Preliminary comments have been provided here for the site plan.  
Please reference EPC PPR 18-028 for an all inclusive list of comments.

### UTE PASS STORAGE FACILITY

# Markup Summary

2 ADA / STANDARD PARKING
SCALE: 1/8"=1'-0"

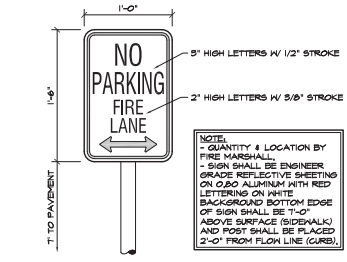
With the addition of the ADA parking please include the following note

"The parties responsible for this plan have familiarized themselves with all current accessibility criteria and specifications and the proposed plan reflects all site elements required by the applicable ADA design standards and guidelines as published by the United States Department of Justice. Approval of this plan by El Paso County does not assure compliance with the ADA or any regulations or guidelines enacted or promulgated under or with respect to such laws."

Also required is an additional page illustrating the ADA route.

1 SITE PLAN
SCALE: 1"=50'-0"

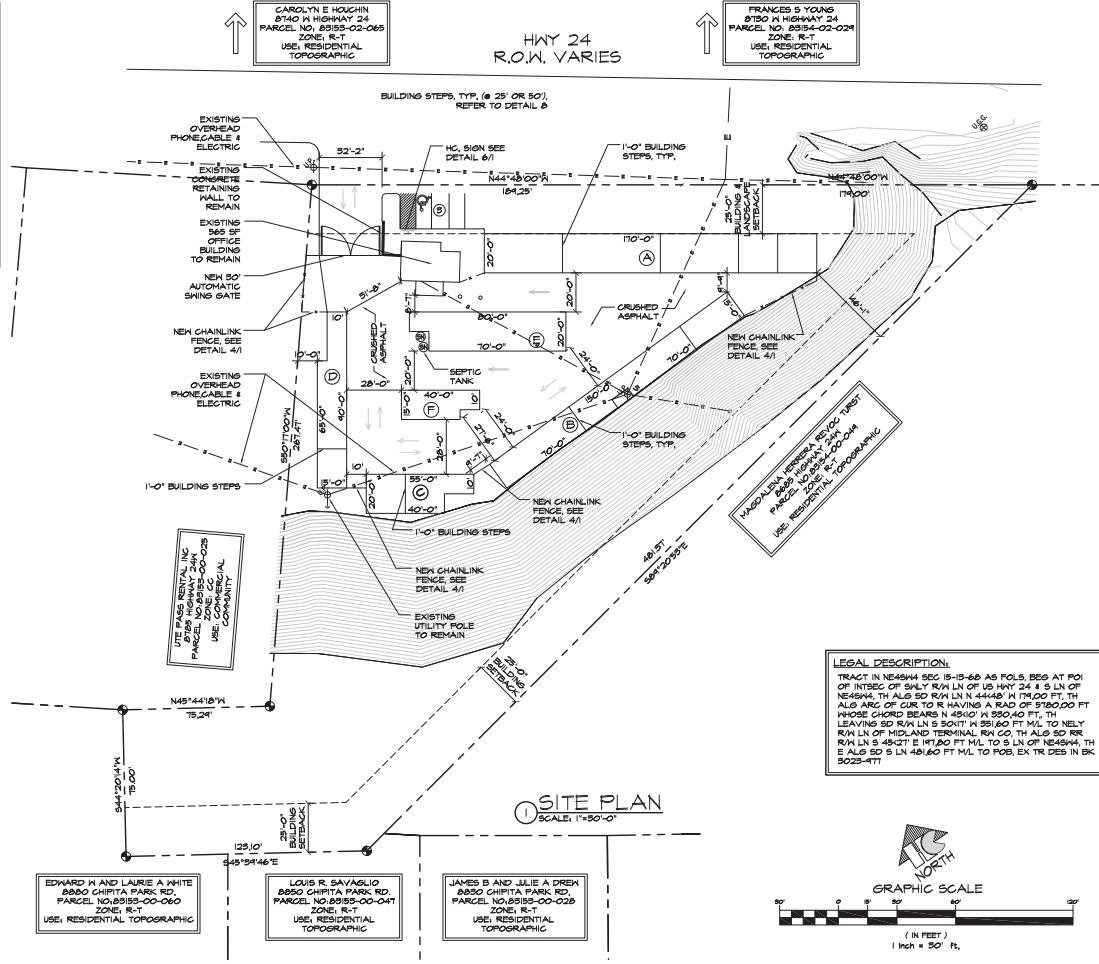
call out on legend what this hatch is.

Please call out floodplain areas.  
Please provide some hatch to distinguish between structures and paved areas.  
please call out of the access is existing or proposed (also call out extents of curb and gutter).

please clarify if this is a retaining wall or a block wall?

please confirm the direction of swing for the proposed gate, please call out the depth that a vehicle has to queue behind the gate and not impact Hwy 24 traffic.

Please make sure that the hatch for the fence is visible so that one can determine the extents of the proposed fence, typical all.

please call out what this looks like (ie c&g, paint?).

please call out, on the plan view, where this curb is to be installed.

Are these individual storage bays? how will they get access, turn around, etc?

Is there a trash enclosure anticipated for this site? Any outside storage areas must be marked, if none are proposed please include on letter of intent and a note on site plan, that no outside storage is permitted.
